AQUIND INTERCONNECTOR

Statement of Common Ground Between
AQUIND Limited and Historic England

Document Ref: 7.5.13

PINS Ref.: EN020022

TITLE:
Figure 14.1 Location of Aquind Interconnector Marine Cable Corridor (UK Sector)

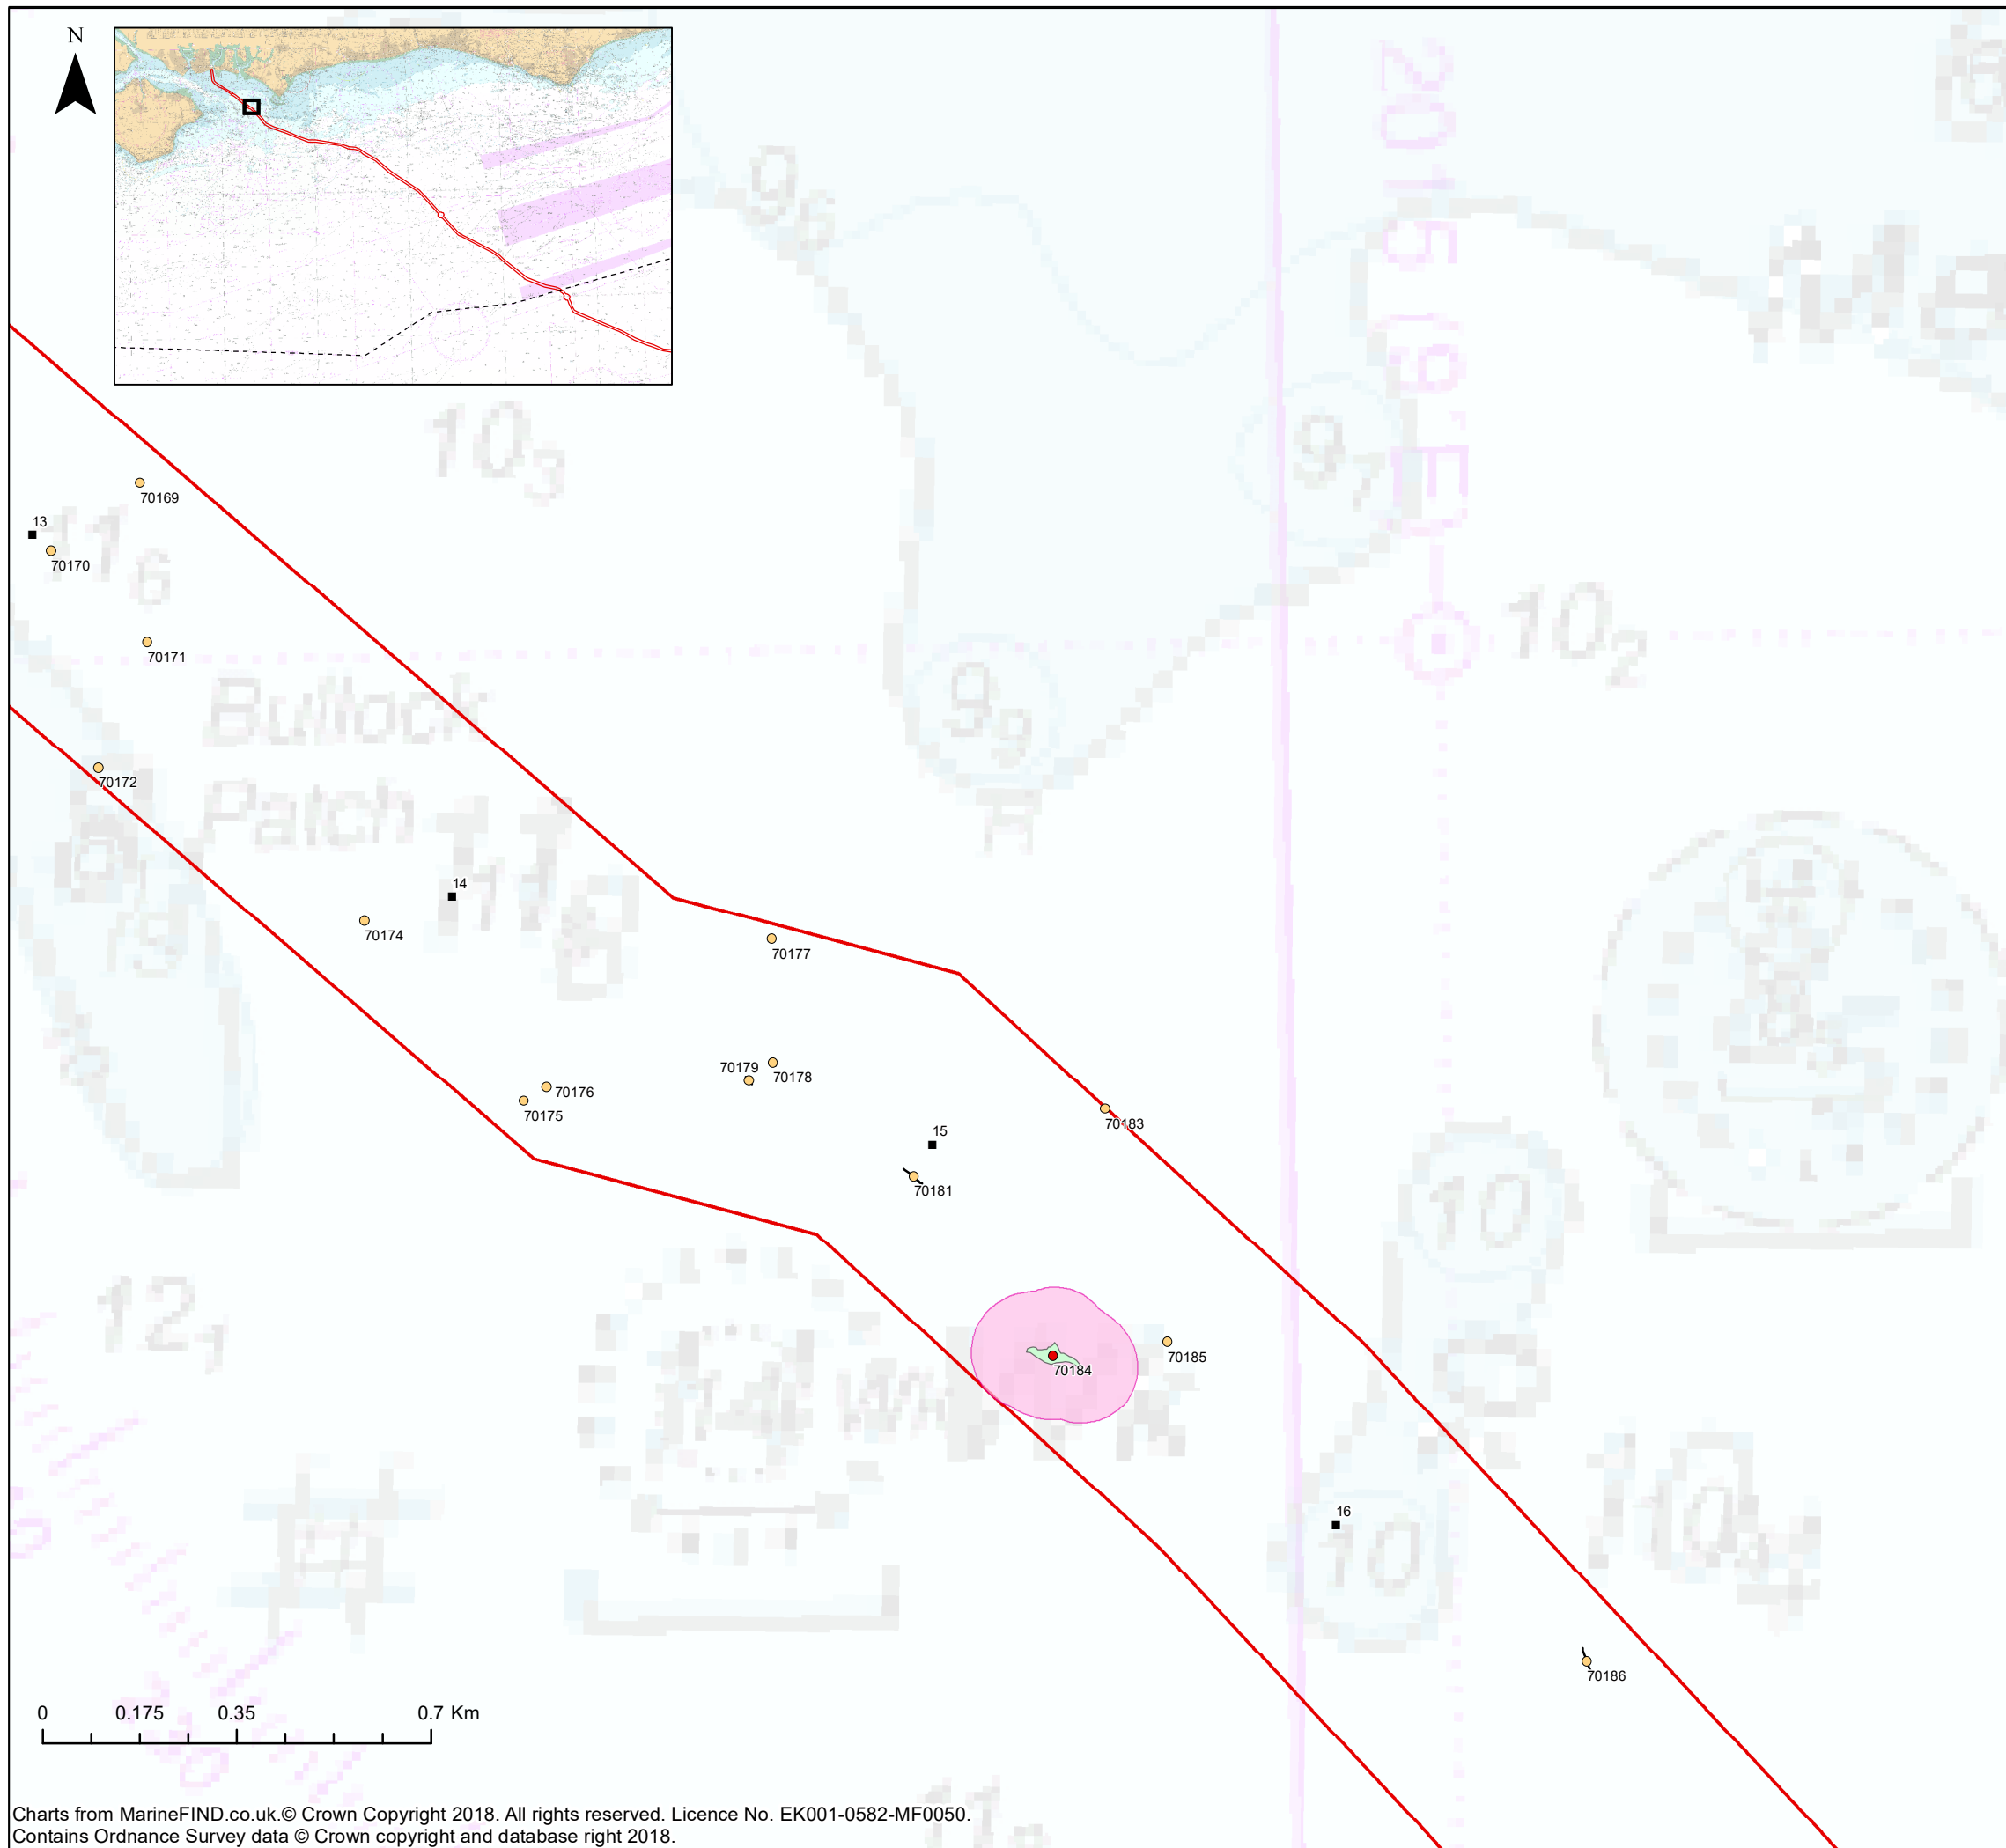
Item No.	Topic	Comment	Applicant's Response
			the project description. Any potential significant environmental effects will be assessed accordingly within the final ES.
9	Marine Archaeology	Sub-section 14.2.2 'Legislation' of Chapter 14 states that there are no Scheduled Monuments within the Proposed Development or ASA. This must be clarified to distinguish this comment as relating to below MHWS as the map of the ASA in Figure 14.1(same Chapter) clearly shows that the ASA buffers extends over not only Fort Cumberland (a scheduled monument) but also over a significant proportion of Portsmouth, Southsea and Langstone Harbour where further designations are present.	<p>Figure 14-1 shows the data collection search area (ASA), but the presented gazetteer is then restricted to the Marine Cable Corridor. So yes, the data collection buffer extends onshore, but only marine and intertidal elements are taken forward in this chapter. Onshore receptors - such as Fort Cumberland - are discussed within the relevant onshore chapter.</p> <p>Figure 14.1 will be updated to make this clearer.</p>
